DATE: January 30, 2023

SUBJECT: Colorado Concrete Crushing
RE: Transportation Memorandum
Response to City of Colorado Springs Comments Memorandum
LSC #S224330

Following are the LSC Transportation Consultants, Inc. responses to the August 2, 2022 Comment Letter prepared by the City of Colorado Springs Traffic Engineering regarding PPR2241.

# Vollmer Road Approved CD

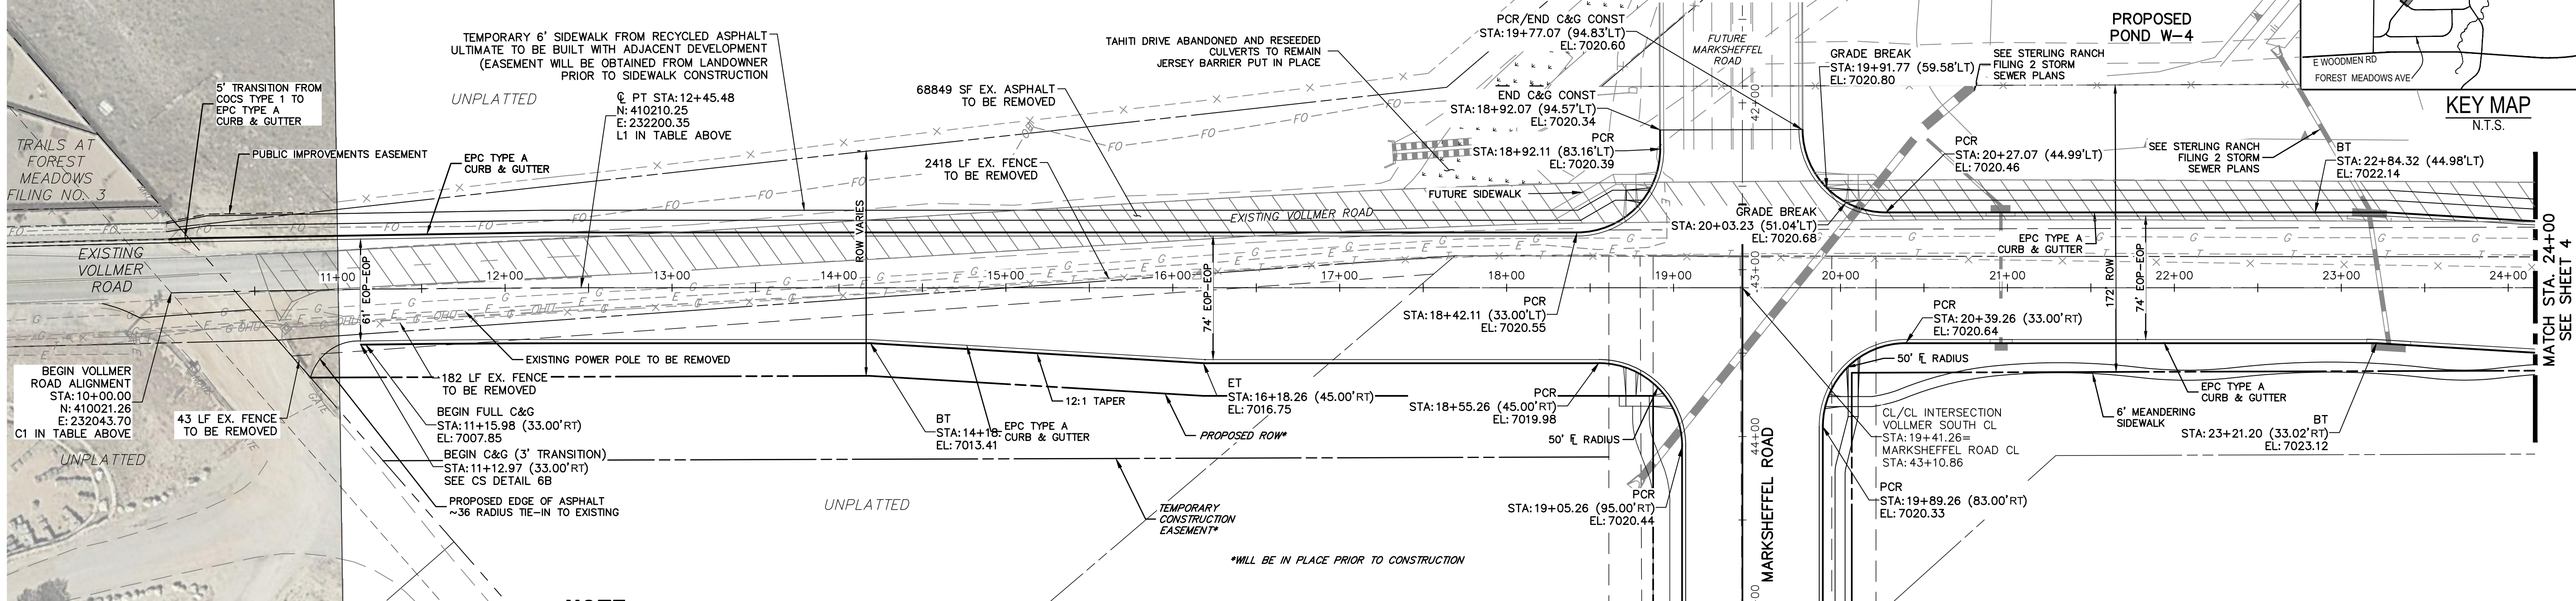
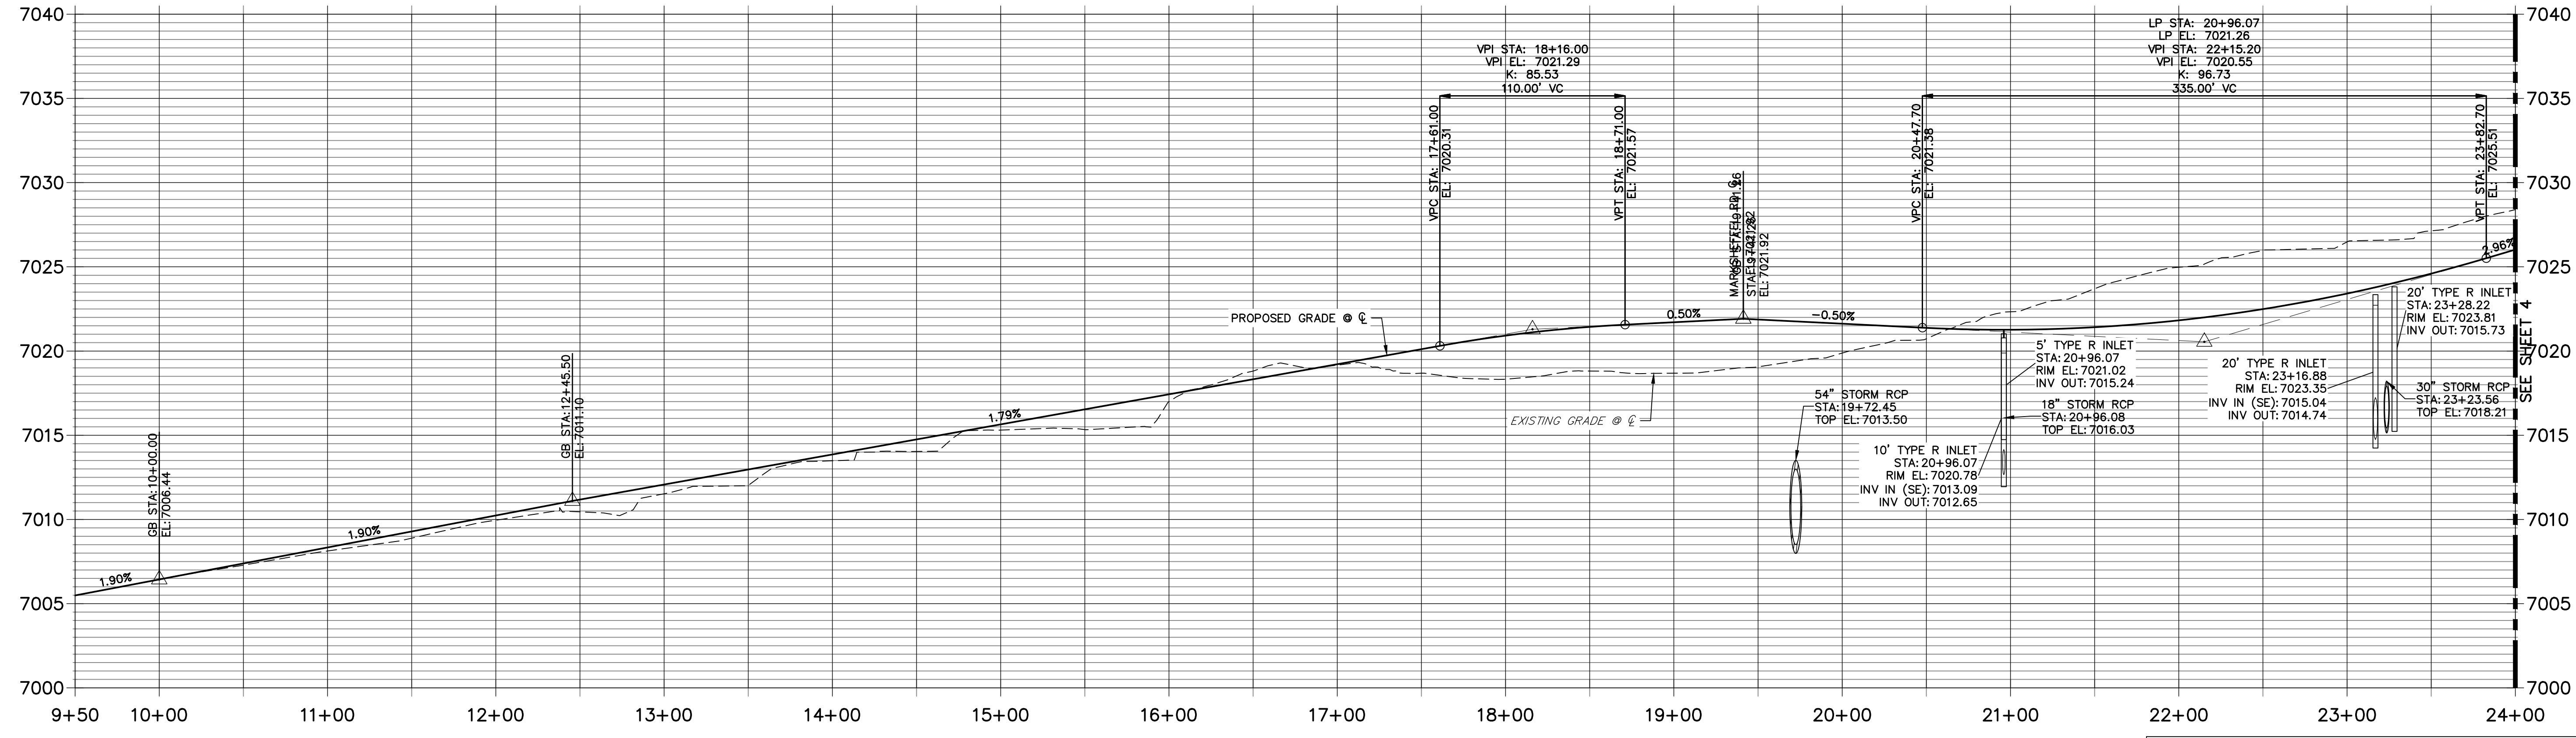
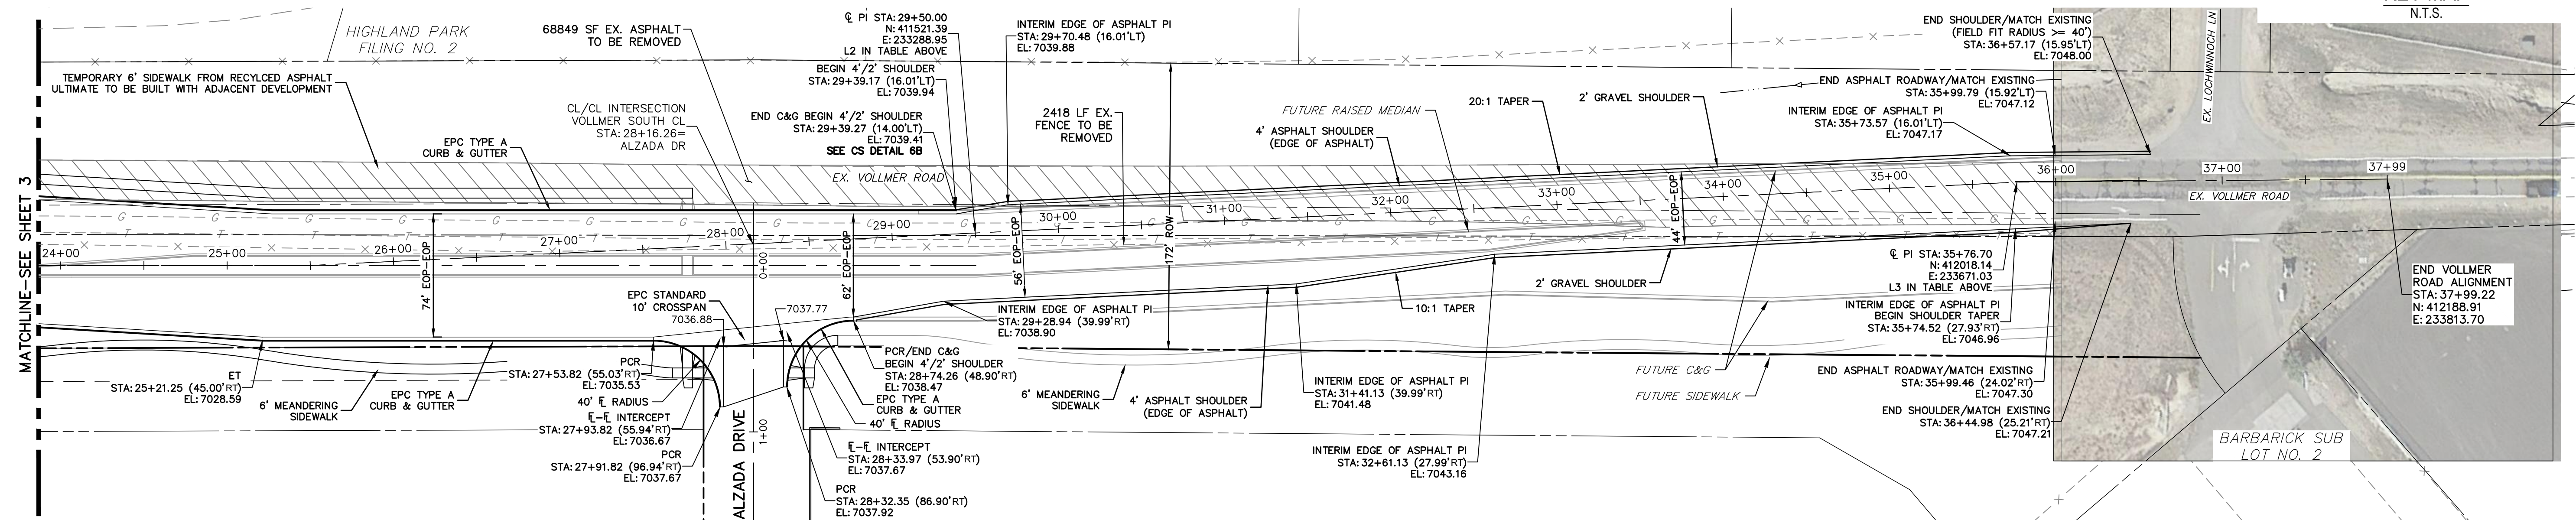
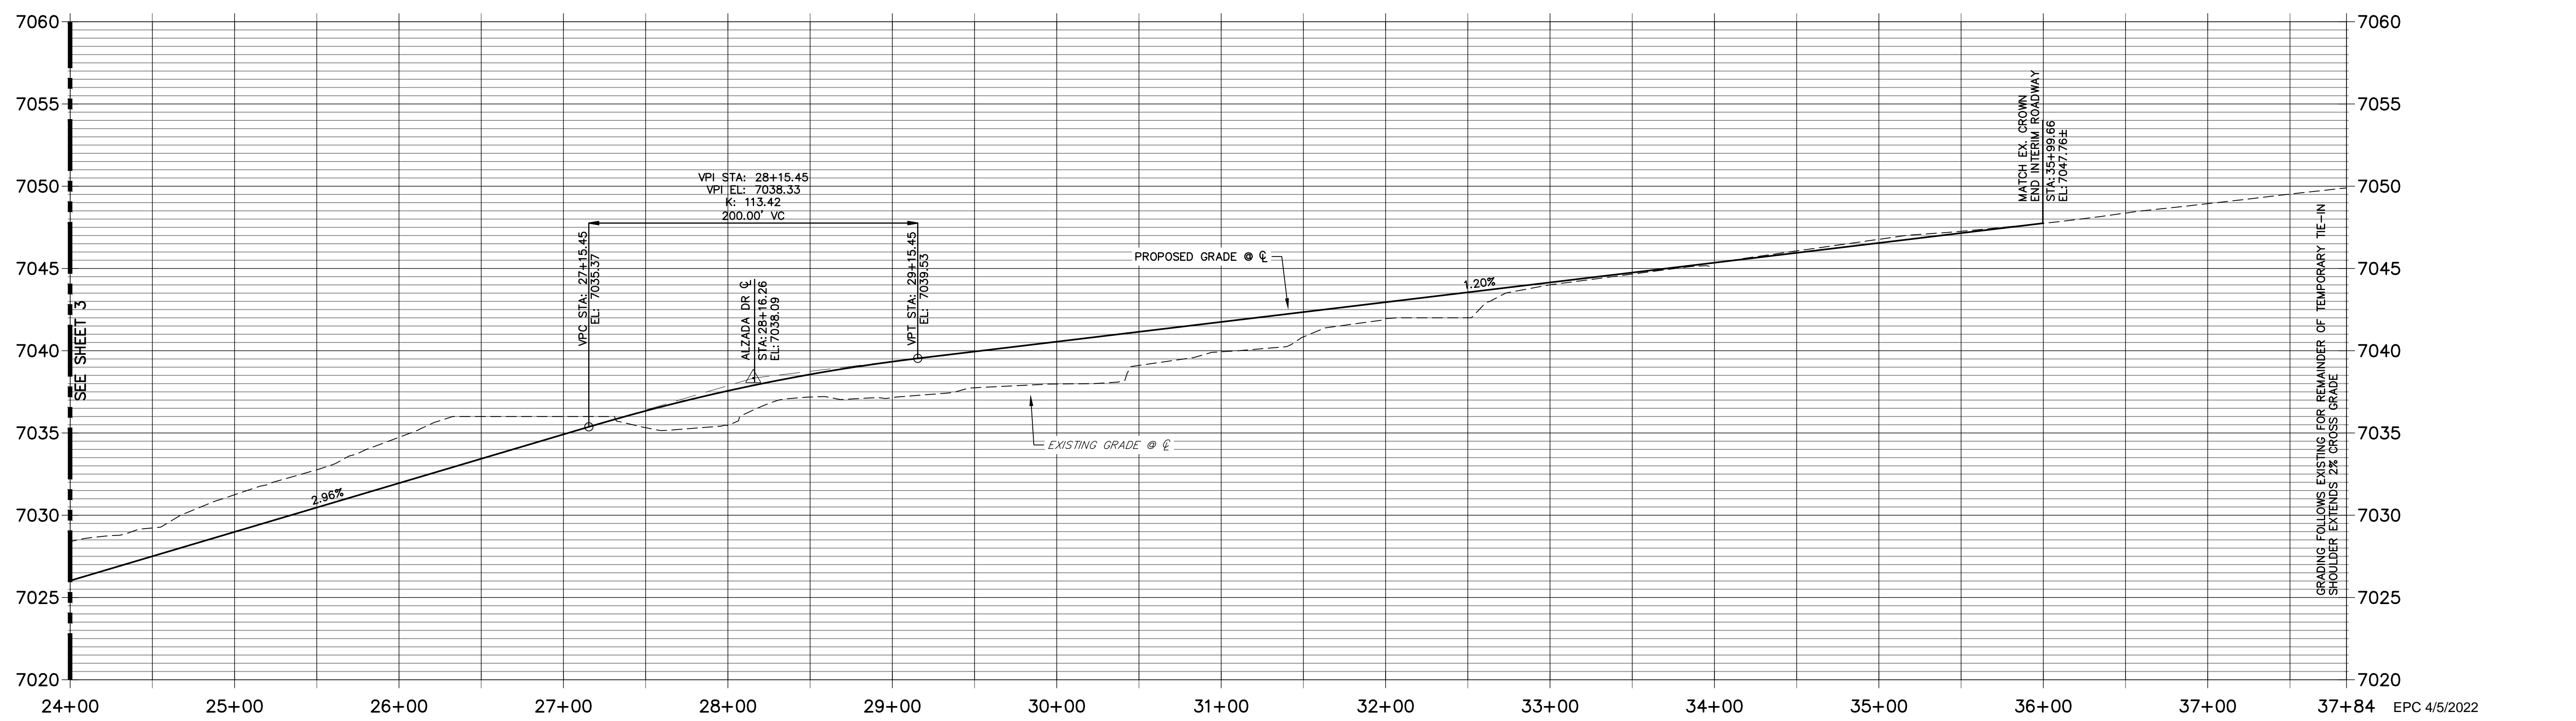
a. *The developer will be responsible to improve Vollmer Road (adjacent to property line) to the ultimate minor arterial cross-section and include a northbound right turn lane at the site access. This turn lane will need to contain 155-foot turn lane and 160-foot long transition taper.*

LSC Response: The memo has been revised to include the right-turn deceleration lane as required by the City. The report also includes a recommendation for a paved shoulder in lieu of improving Vollmer to the full minor arterial cross section (not sufficient ROW at this time).
